REVIEW OF AN ENVIRONMENTAL ASSESSMENT

THE PROPOSED REDEVELOPMENT OF CRONULLA MARINA

60 Waratah Street, Cronulla

Cronulla Marina – Advice to the Director General

Figure 6 – Proposed Slipway Layout

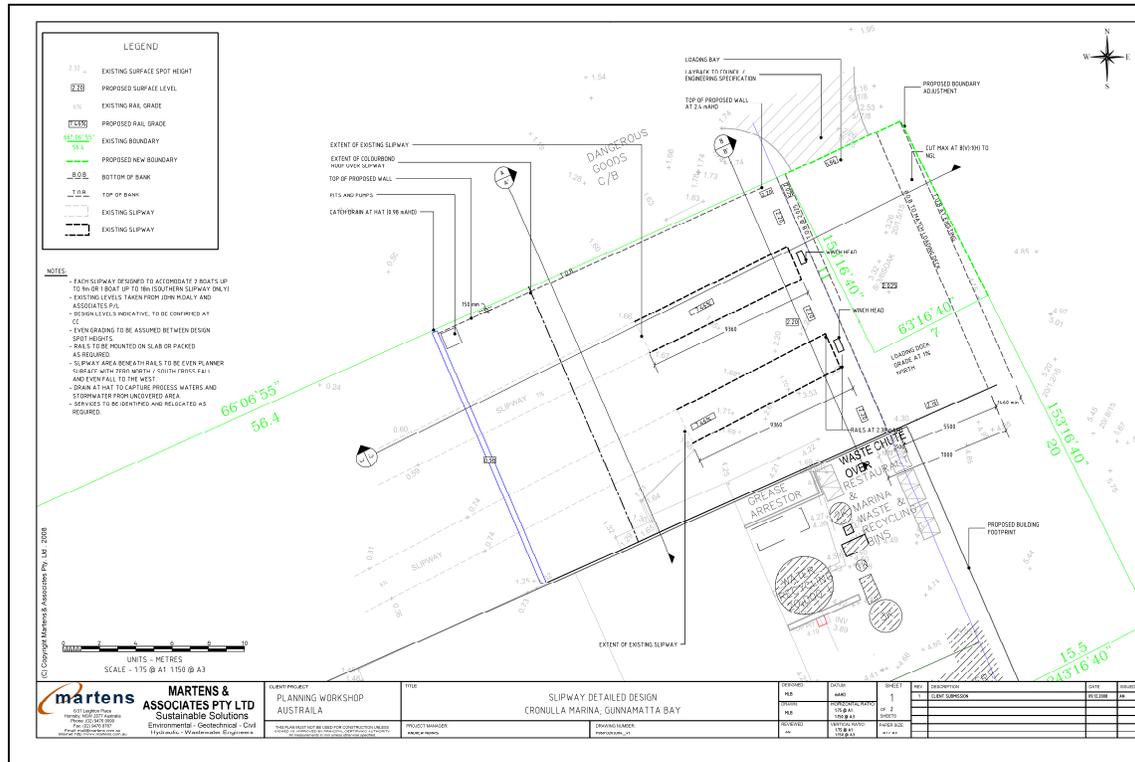
The EPA first issued "Best Management Practices for Marinas & Slipways" in 1997. This document set dimensional controls for slipway design and included a requirement for vessels to be slipped onto hardstands with a minimum finished level of 1.525 AHD. 150mm of bunding was also a set requirement.

- Does not require the hardstand at RL. 1.525 AHD.
- Does set global requirements for Slipway use and management.
